ENG-PUDSP21001-R1-TIS-Redlines.pdf Markup Summary

Exhibit 1

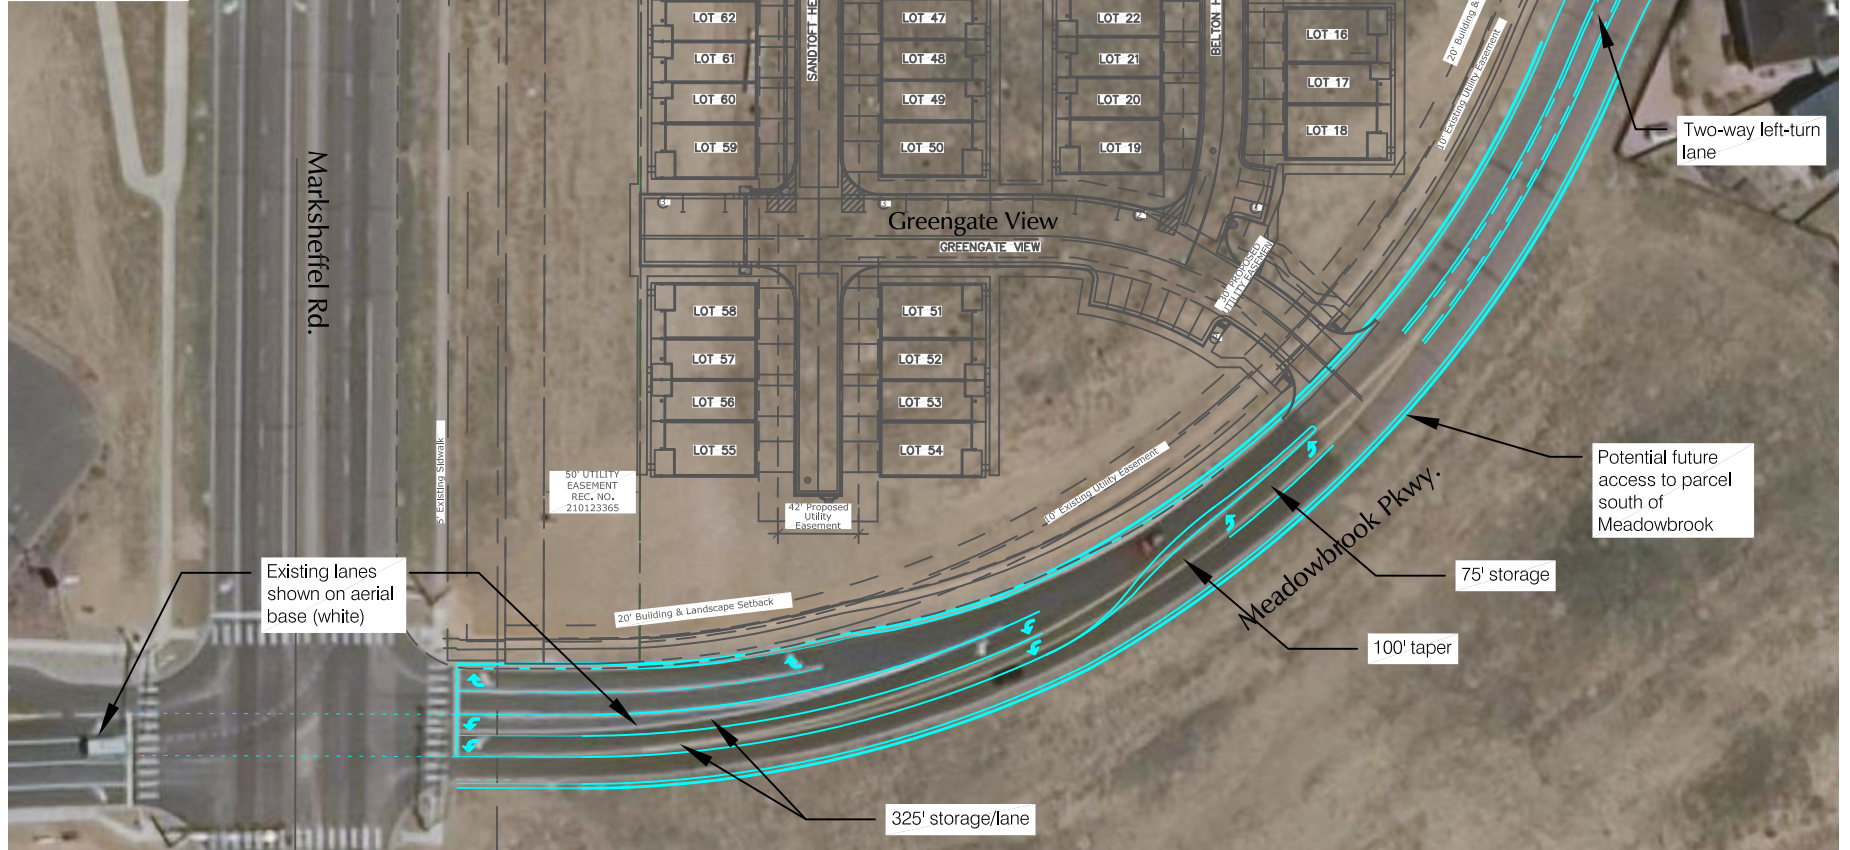
In both the background and total traffic scenario, dual westbound left turn lanes are required

provide an exhibit to scale showing how this can be done

provide exhibit

please provide exhibit
